Review Response

Project Name: McMillan Dock Repair

Response To: SHL23-035 SUB2

TO BE REPAIRED

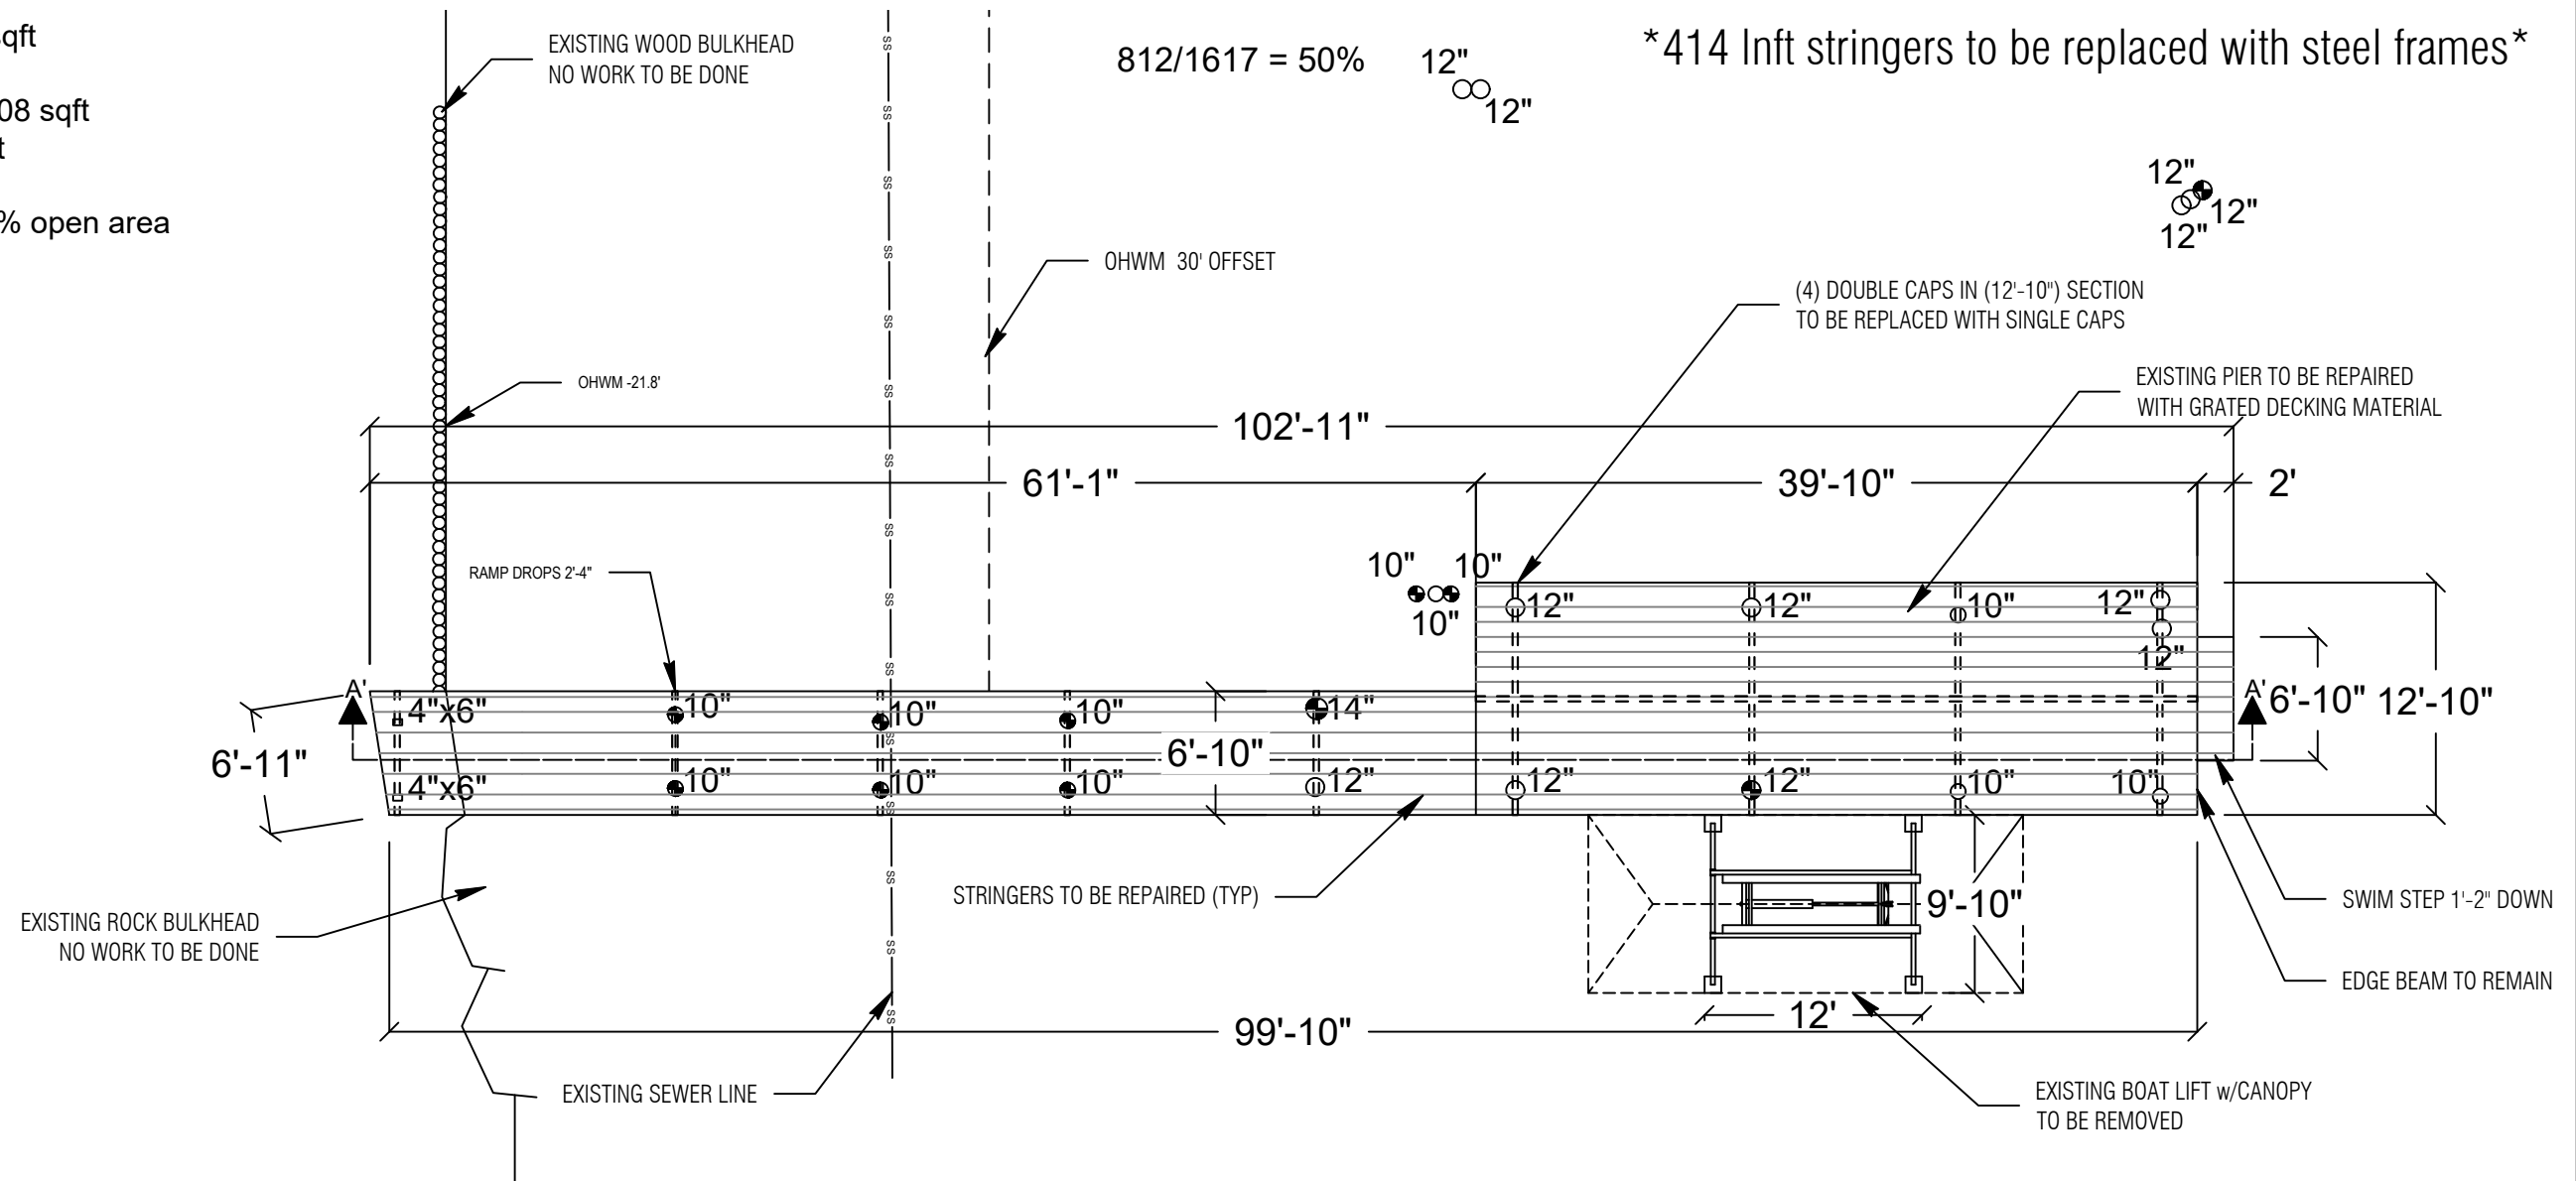
1. All stringers will be replaced with steel frames, each steel frame will account for less than 50% of the linear footage of wood stringers to be replaced. (I.E. 994 lnft of wood stringer to be replaced with 414 lnft of steel frames) Noted on repair calculations.
2. Lift and Canopy to be removed.
